## Re: 1 Joy Place- PB conditions of approval to be addressed

**Jean Fraser** <jf@portlandmaine.gov>

To: Michael Tadema-Wielandt <mtw@terradyconsultants.com>

A1.00

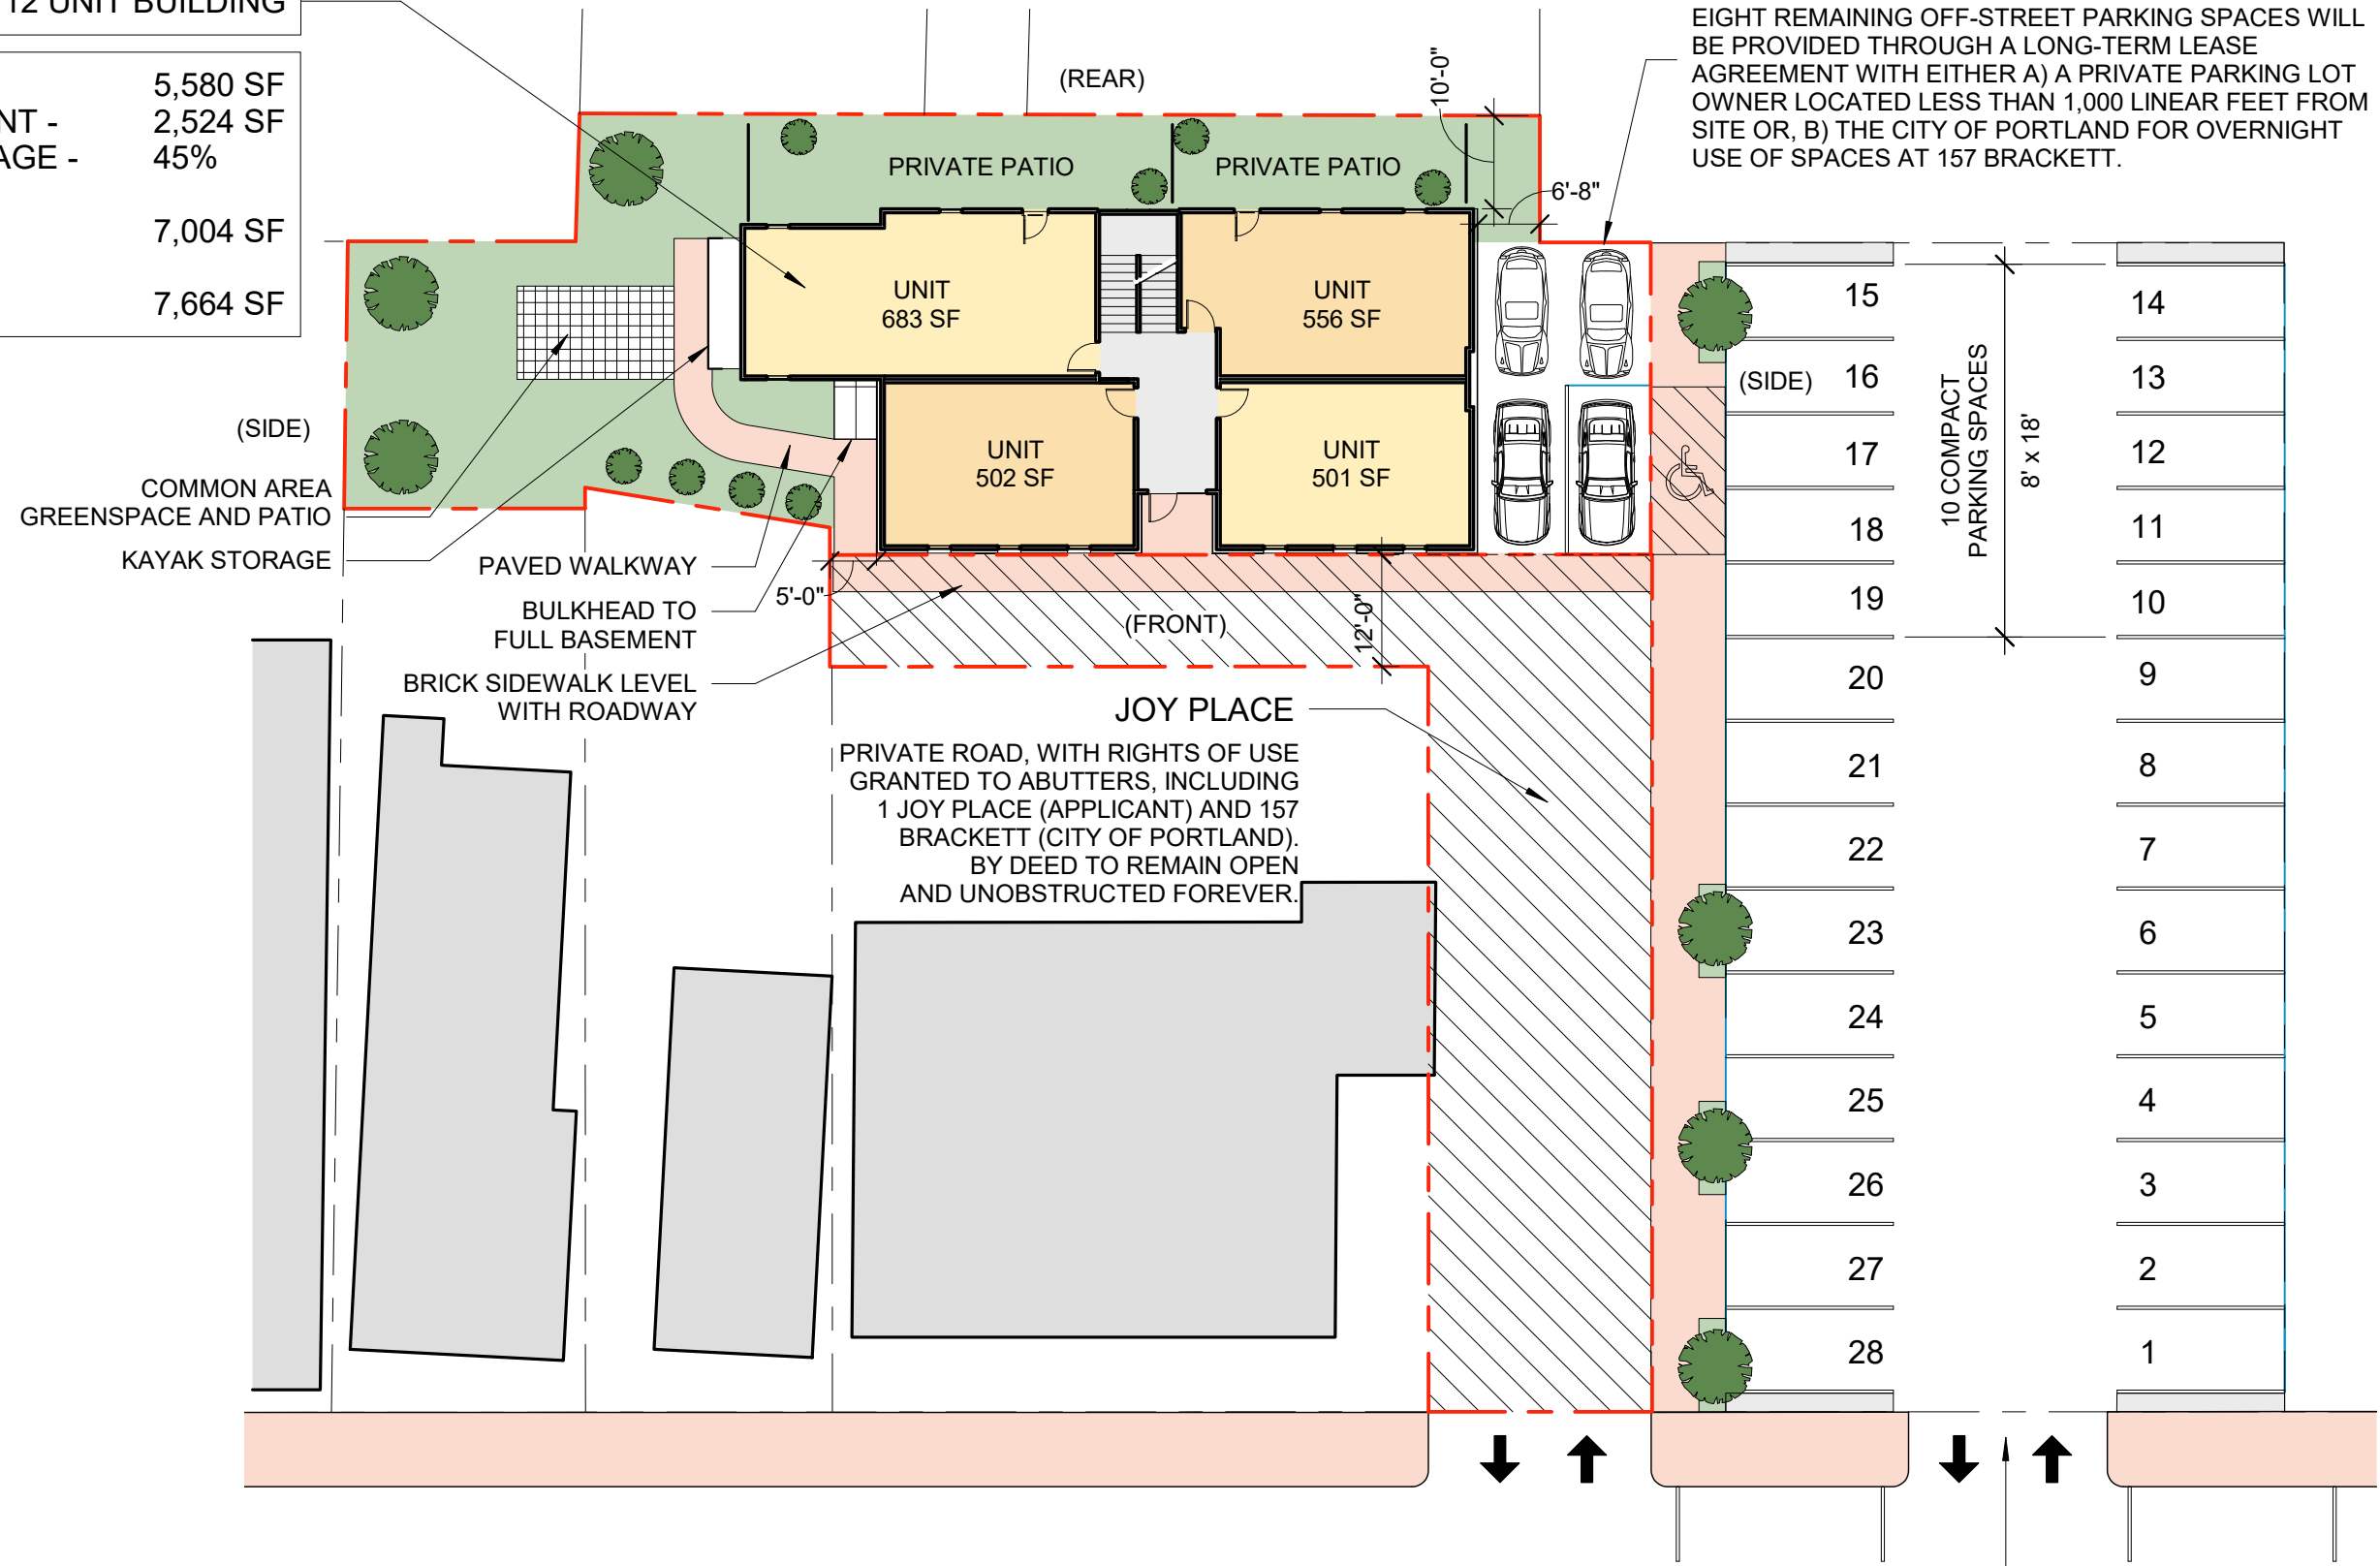
The Site Plan and Utility Plan uploaded 3.20.18 are fine and I agree the light spacing works as you suggested.

You will notice that we addressed your comment on the light spacing in a slightly different way than suggested. We eliminated the 6<sup>th</sup> bollard light along Joy Place and moved the proposed light pole to the bollard's former location. There are now 5 bollards and one pole mounted light along the property line, spaced equally. We felt that by moving the light pole farther into the site, it would be more susceptible to being damaged by a vehicle maneuvering out of the parking spaces.

A1.04

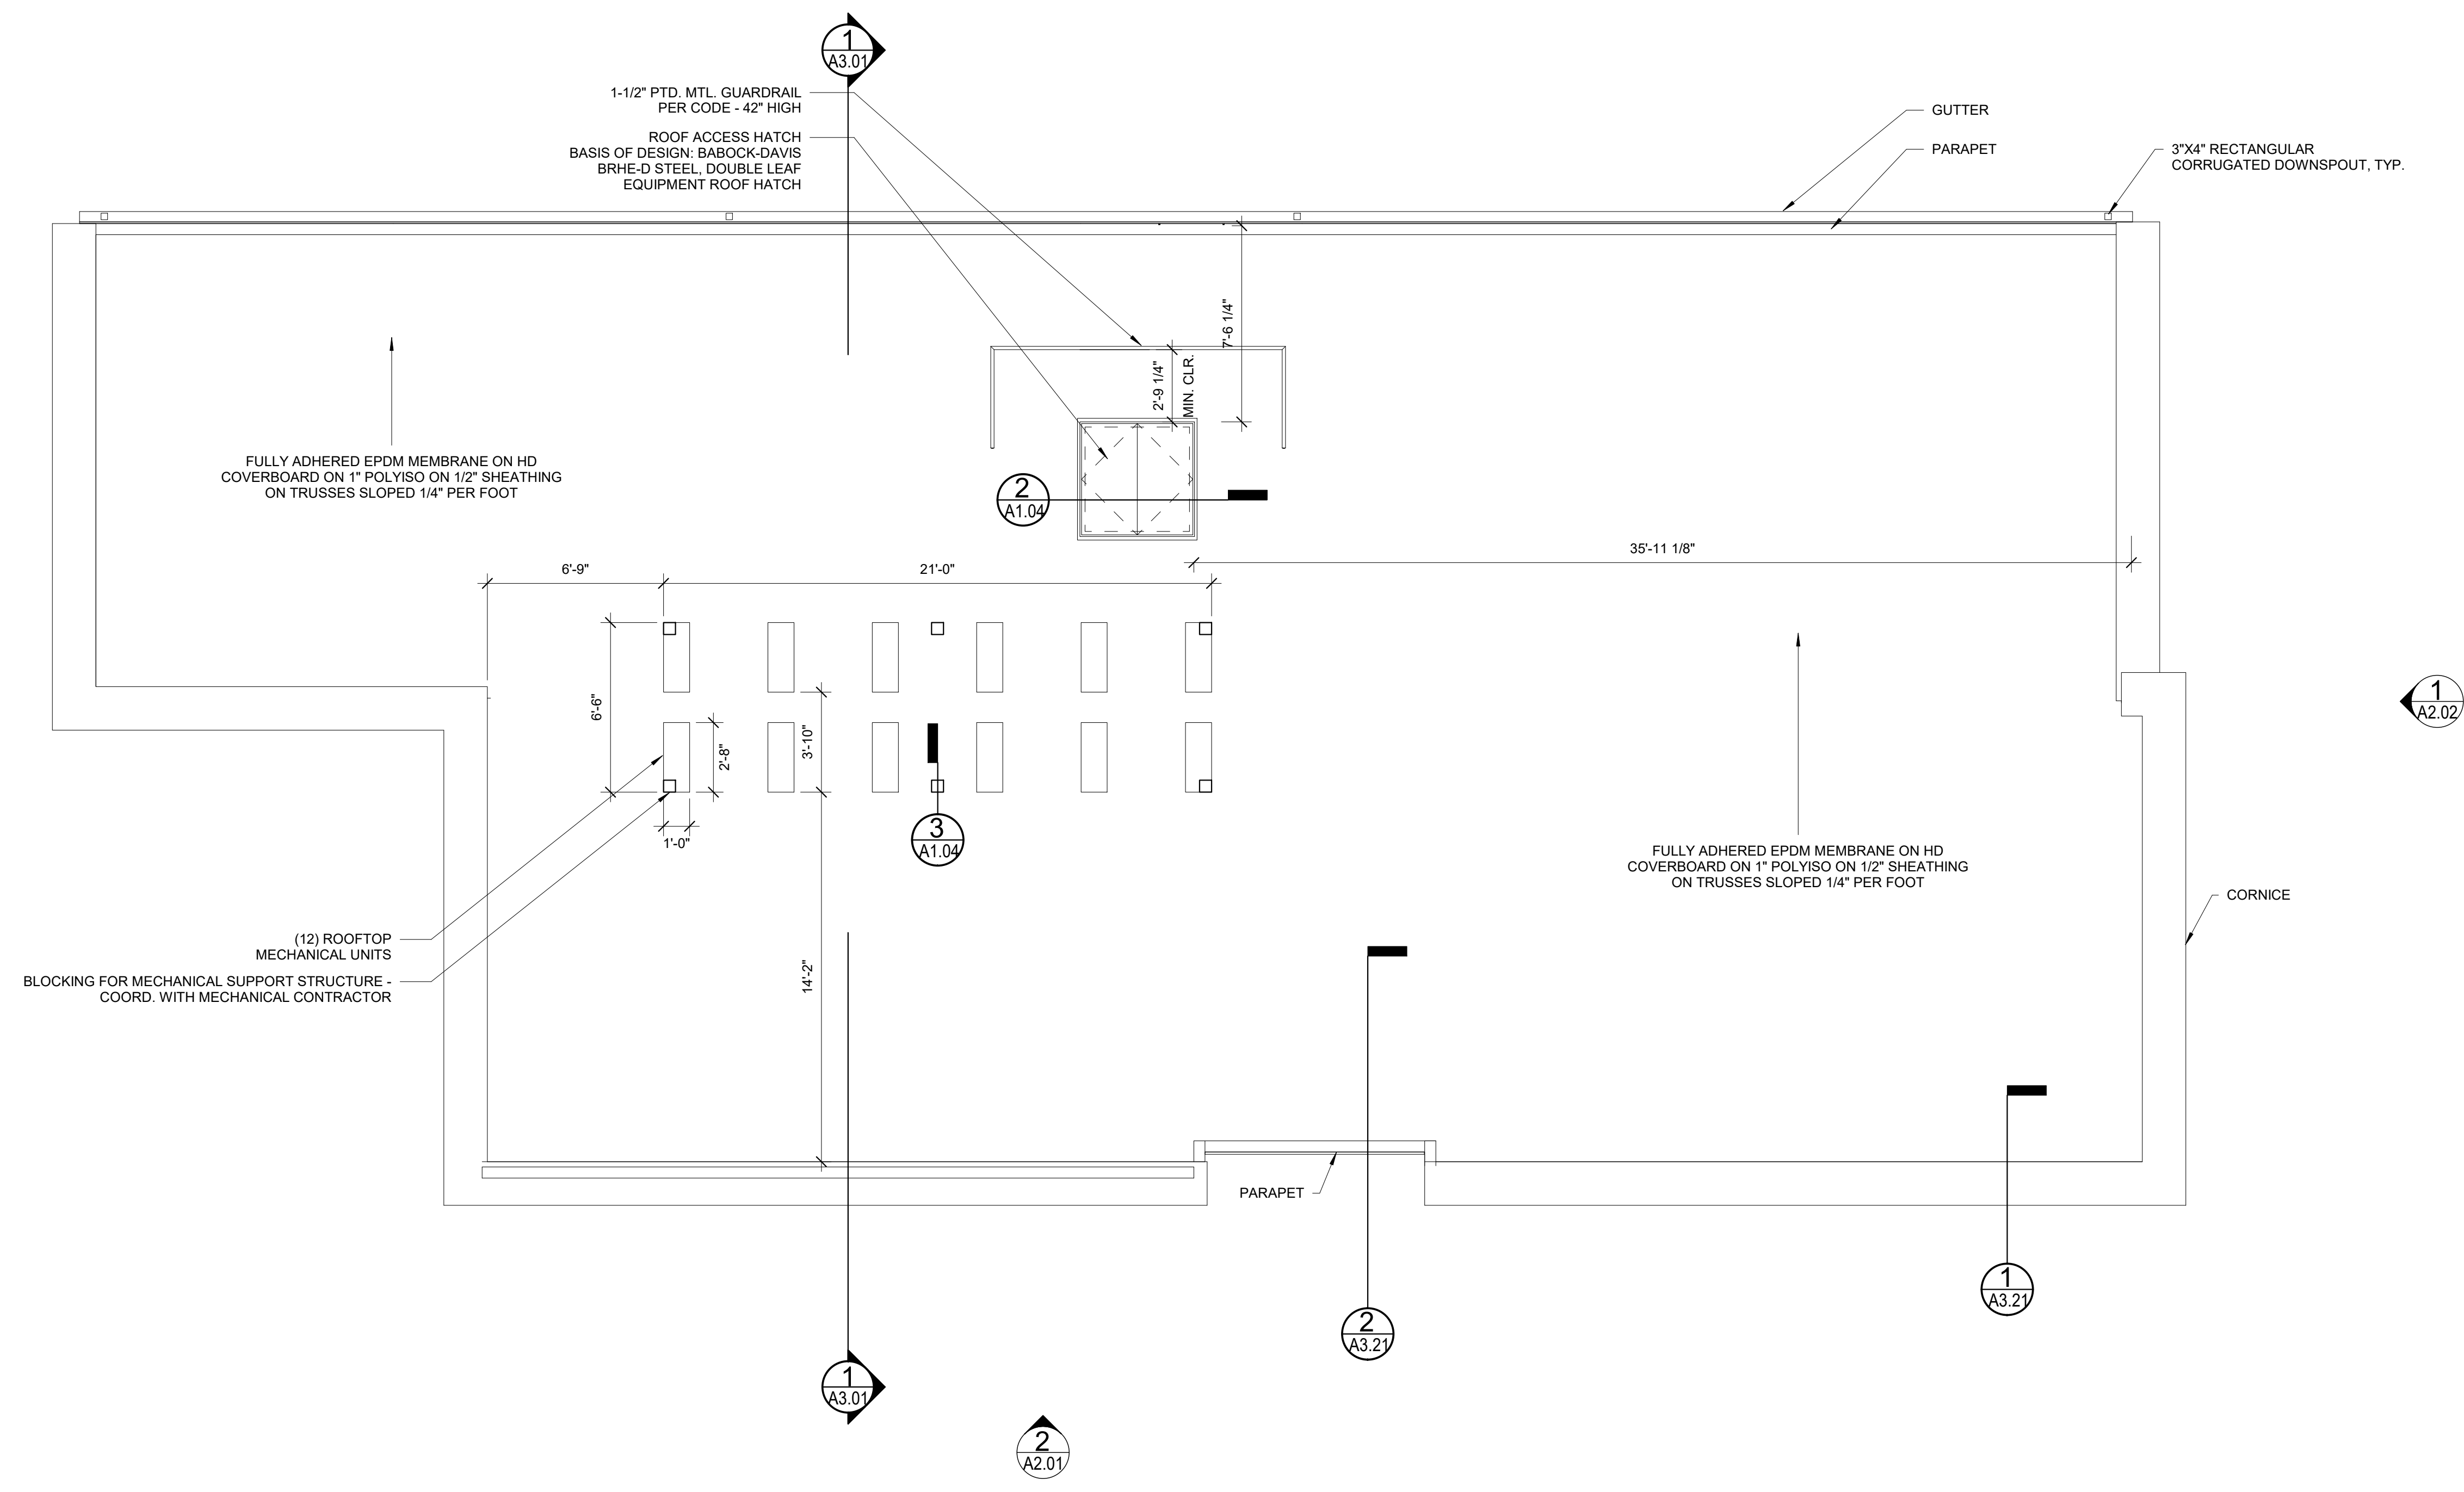
Just to note I have the info from David Lloyd regarding the HVAC on the roof and this is under review - I will get back to you next week when the reviewer gets back from vacation.
